As we discussed in our conversation at your office on January 5, 1998, I am writing this letter to explain why we are submitting an "after-the-fact" Hydrology Report for our property at 718 Mountain Road NW (Lot 408-A, Armijo Add'n, J14-D125).

REFERENCE: Grading and Drainage Plan for Lot numbered 408-A in Block 37, Perfecto Armijo and Brothers Addition, (recorded June 12, 1992, V 92C, F117). (City address 718 Mountain Road, NW, 'Drainage report number J14-D125).

***RE: LOT 408-A (J14-D125). GRADING AND DRAINAGE PLAN FOR SITE
DEVELOPMENT PLAN, BUILDING PERMIT, AND CERTIFICATE OF
OCCUPANCY APPROVALS. ENGINEER'S STAMP DATE IS NOT LEGIBLE.***

GRADING AND DRAINAGE PLAN  
LOT 408-A  
718 MOUNTAIN RD. NW

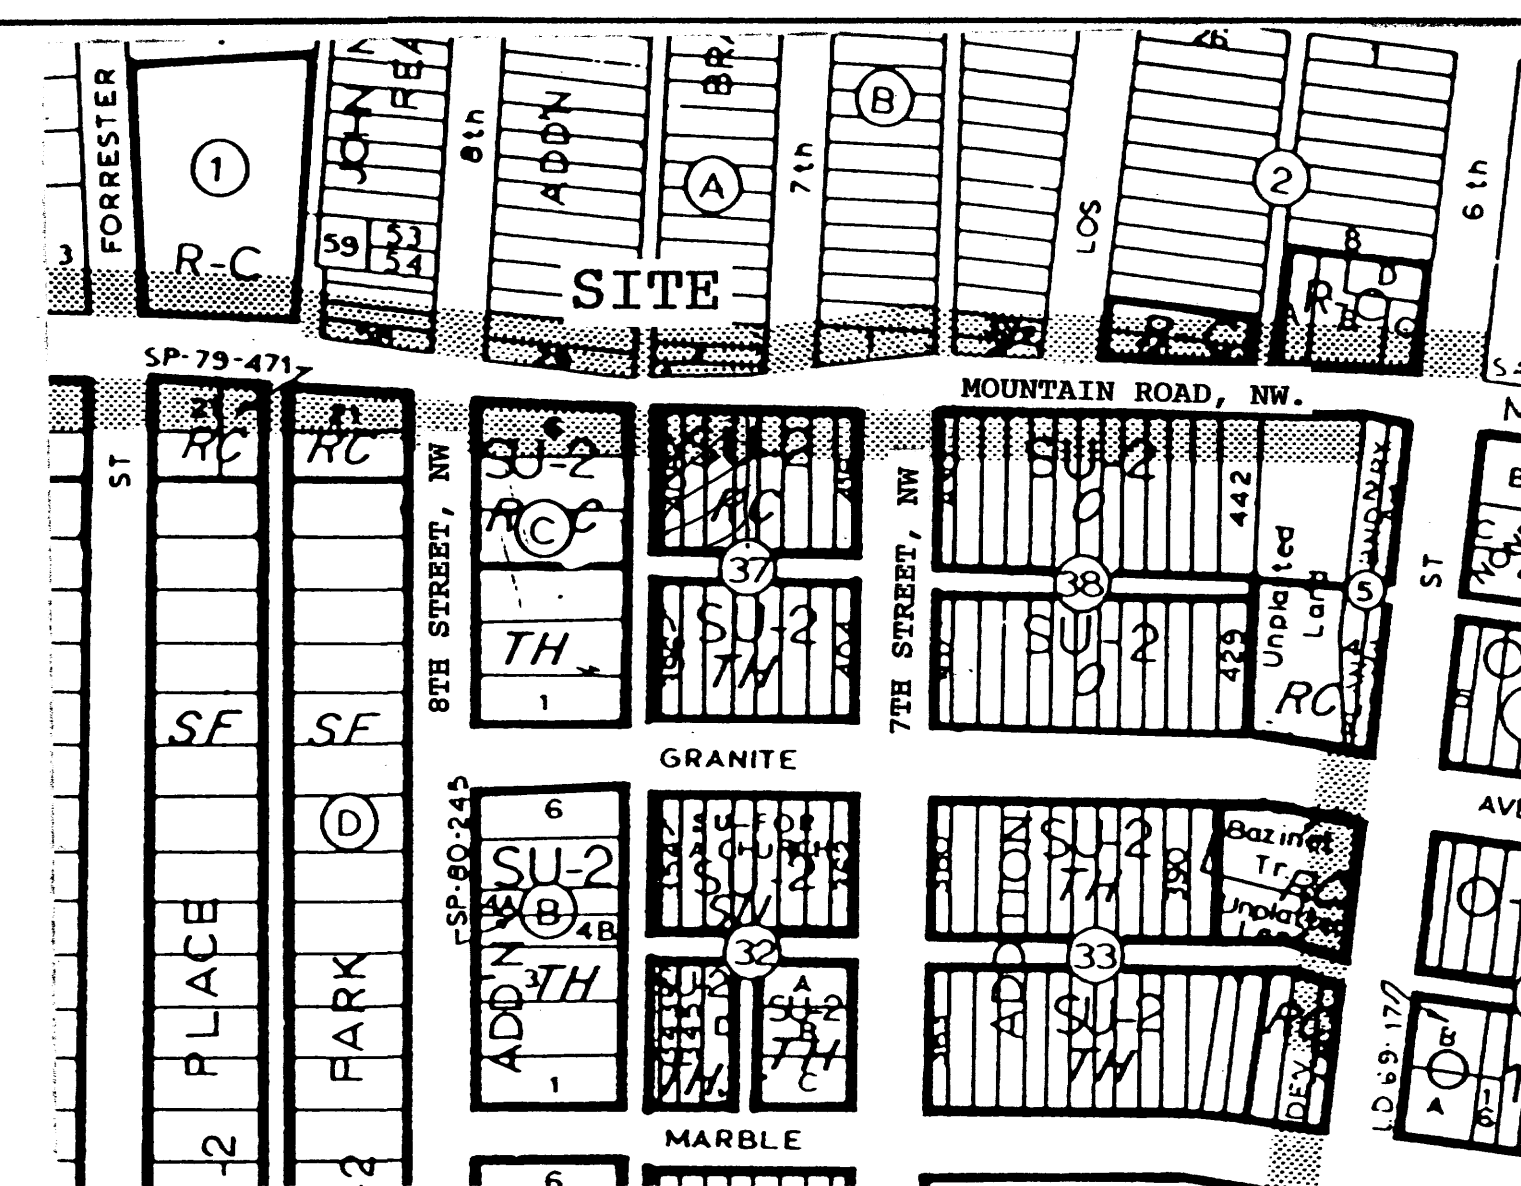
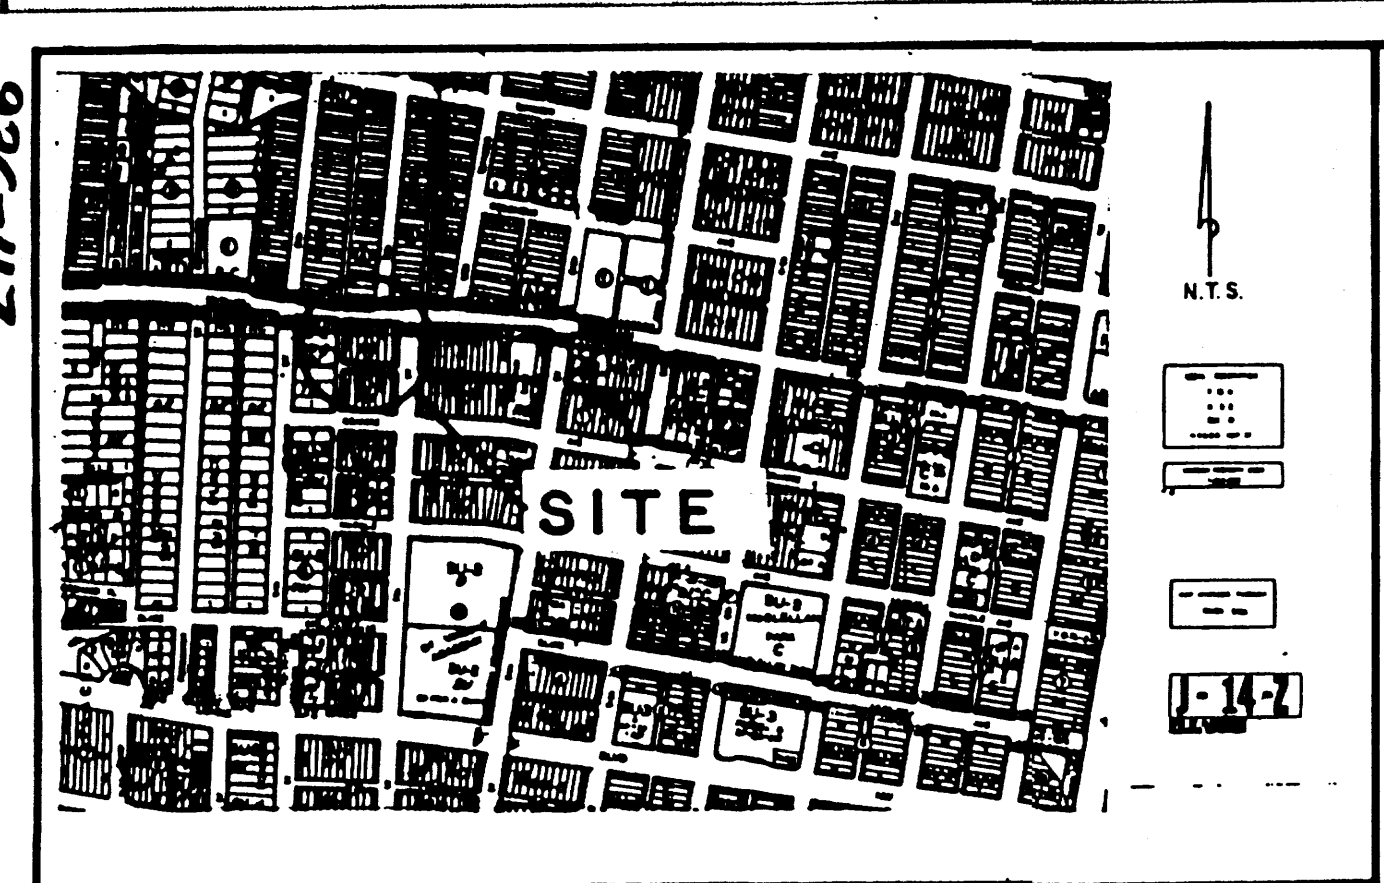
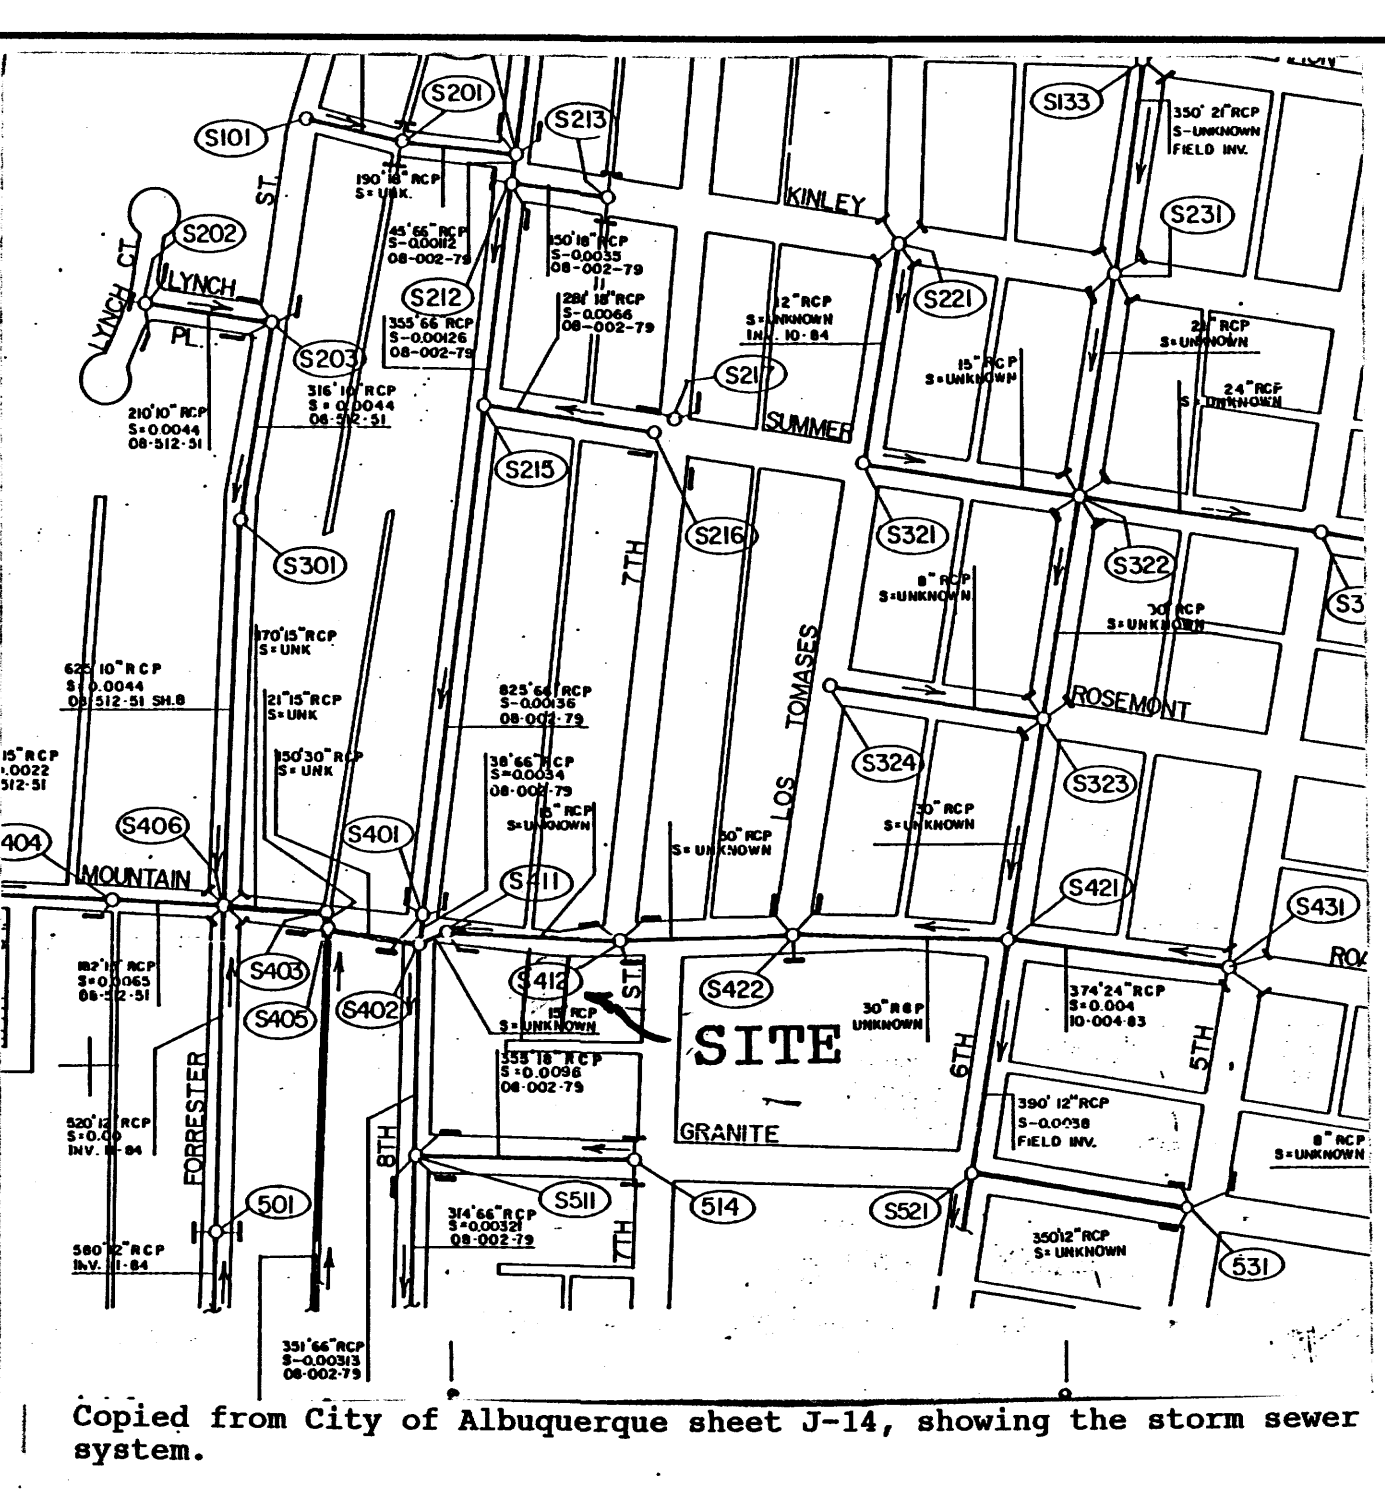
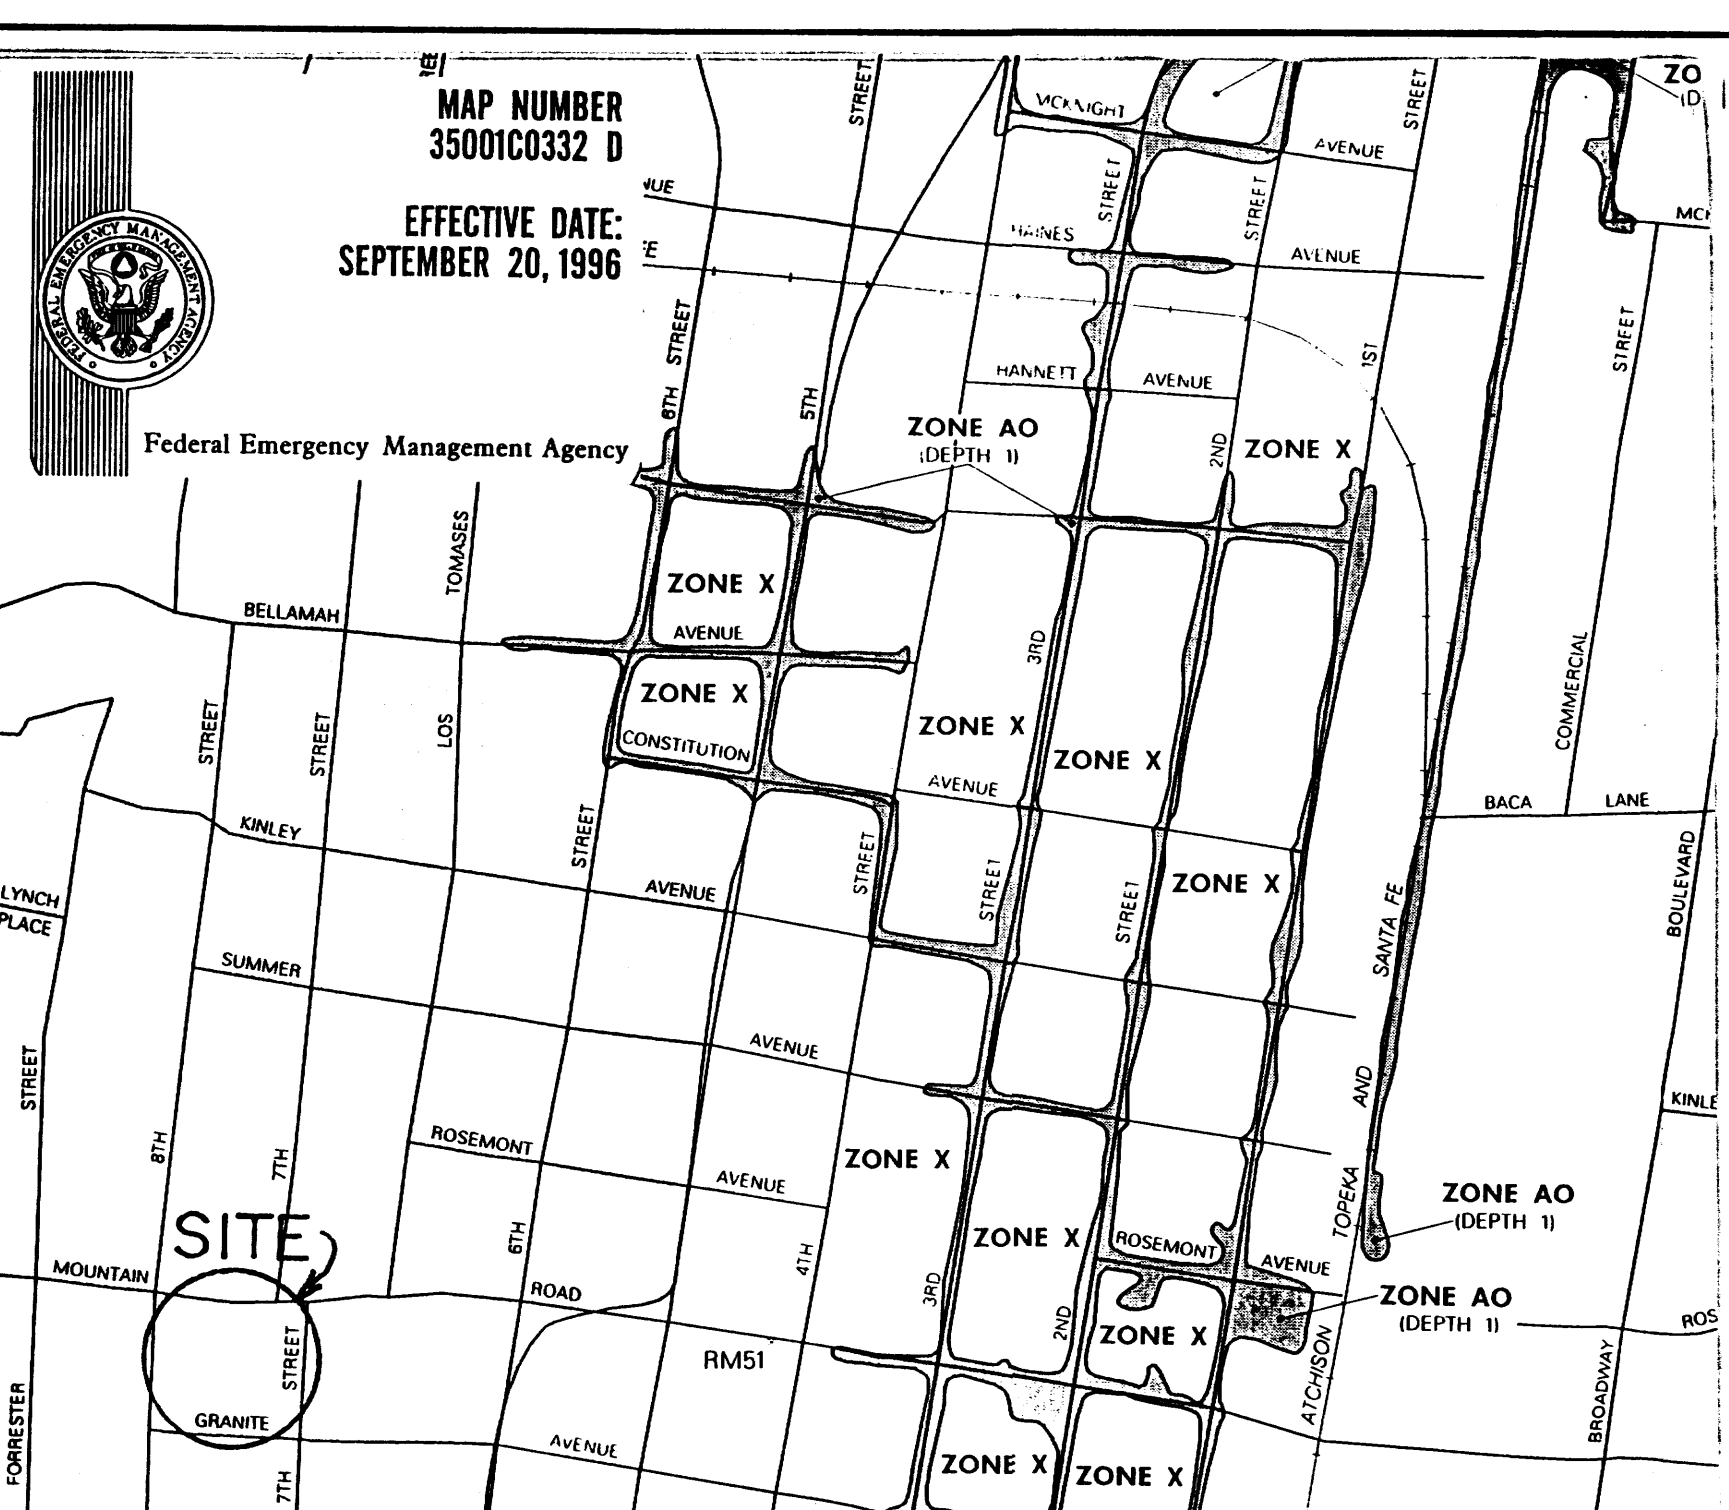
1. It appears that this site is developed with buildings 1 - 4. I am unable to tell what you want you propose to build. Why do you need a Building Permit?
2. What type of Site Development approval are you seeking?
3. Provide a legend.
4. Are you providing enough right-of-way for the City to install a sidewalk?

In answer to the other questions posed in your letter of December 24, 1997, I will speak to Mr. Kortum regarding the provision of a legend and a legible date on the Engineer's stamp. In answer to question 4, we have allowed sufficient room for a sidewalk which is scheduled to be installed this spring as part of an overall redesign and rehabilitation of Mountain Road.

Comment 3: A legend is now shown on the drawings. The current drawing bears an engineers signature dated January 14, 1998.
